Ecological comments

Planning Application No: **3/2013/0161**

Proposals: **Outline application for the erection of 5no. open market dwellings and 6no. social housing dwellings**

Location: **Strawberry Fields**

PHASE 2 - PROPOSED SITE PLAN

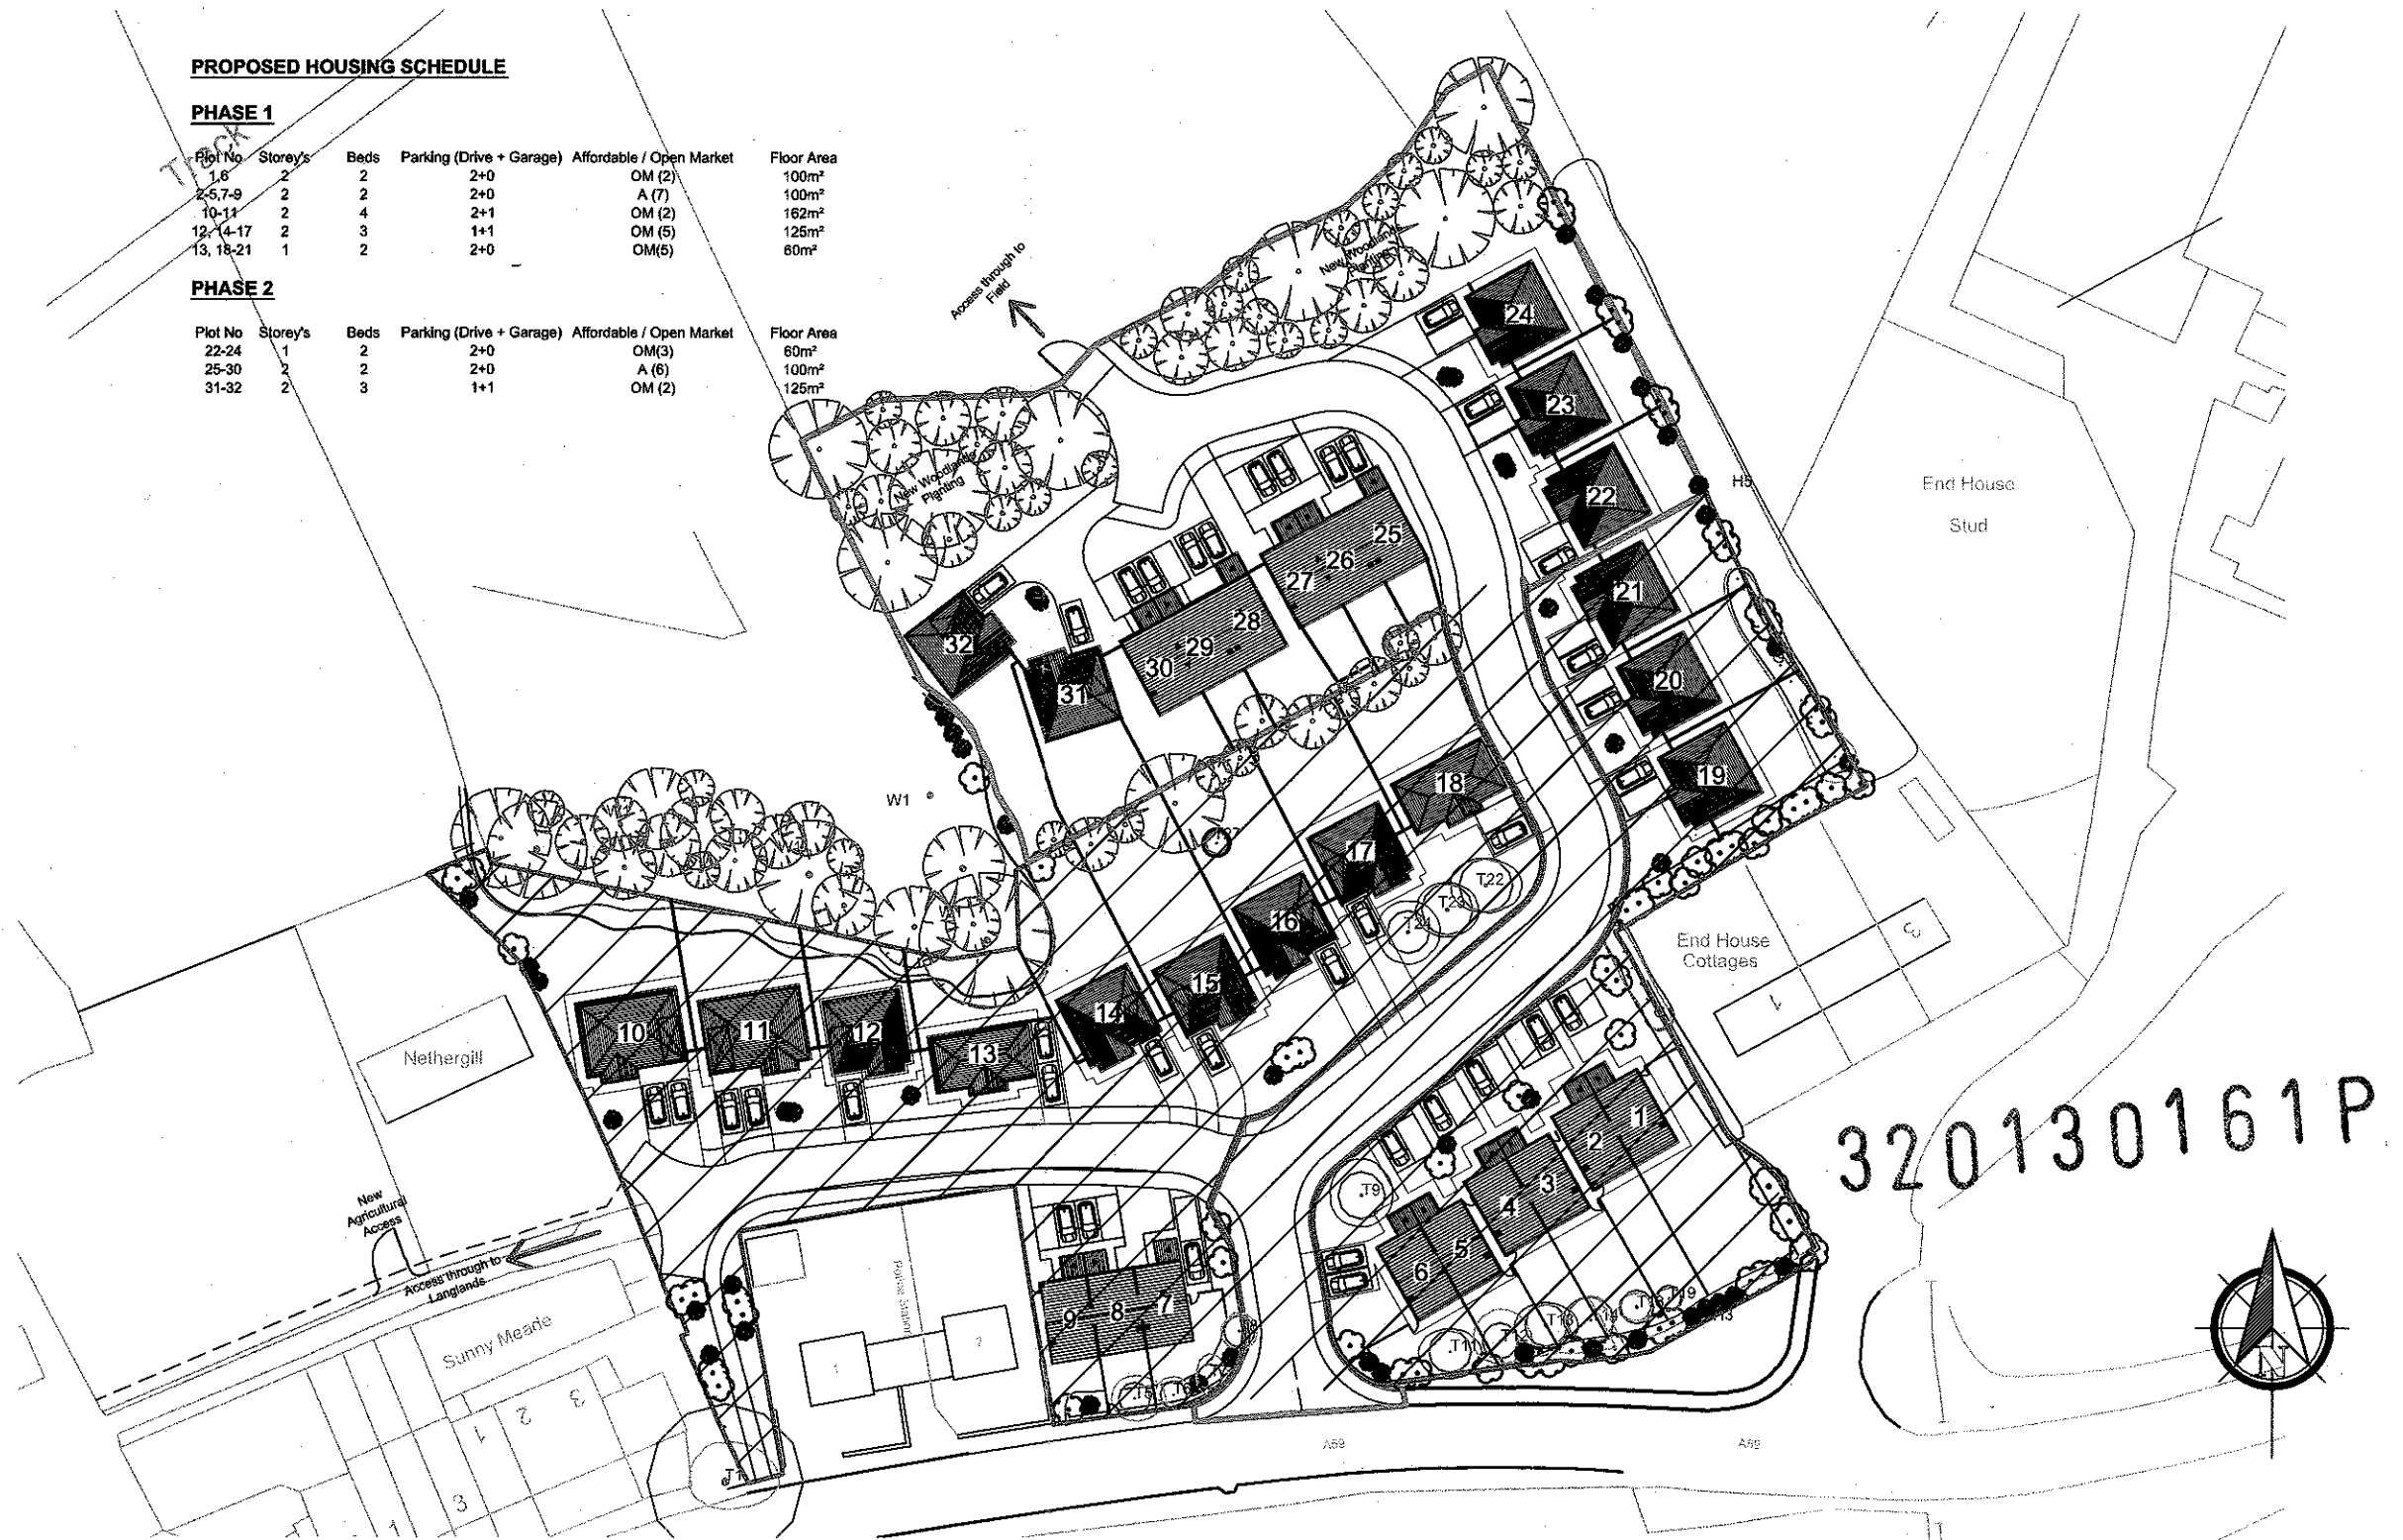
Although the submitted plans show the hedgerow along the eastern boundary of the site will be retained, gardens back onto this hedgerow (and the area of woodland) and the development proposals may result in a reduction of their biodiversity value (for example through garden escapes, green waste tipping, gardening of the hedgerow by residents, increased disturbance by people and their pets resulting in reduced functionality (for example reducing value for breeding birds)).

In order to avoid inappropriate management of the hedgerow by residents, the proposed development should be designed with an adequate buffer/barrier between the gardens and hedgerow and enough space to allow the hedgerow to grow naturally.

In addition, to compensate for any impacts it would be appropriate to ensure that the hedgerow is managed as a tall bushy hedgerow for wildlife and for there to be additional planting elsewhere. The submitted plans show new woodland planting to the north of the site. This planting has the potential to compensate for any impacts and indeed has the potential to enhance the biodiversity value of the site. This woodland planting should comprise native species appropriate to the locality. Guidance is given in Lancashire County Council's Supplementary Planning Guidance on Landscape and Heritage
<http://www.lancashire.gov.uk/corporate/web/view.asp?siteid=3654&pageid=11650&e=e>.
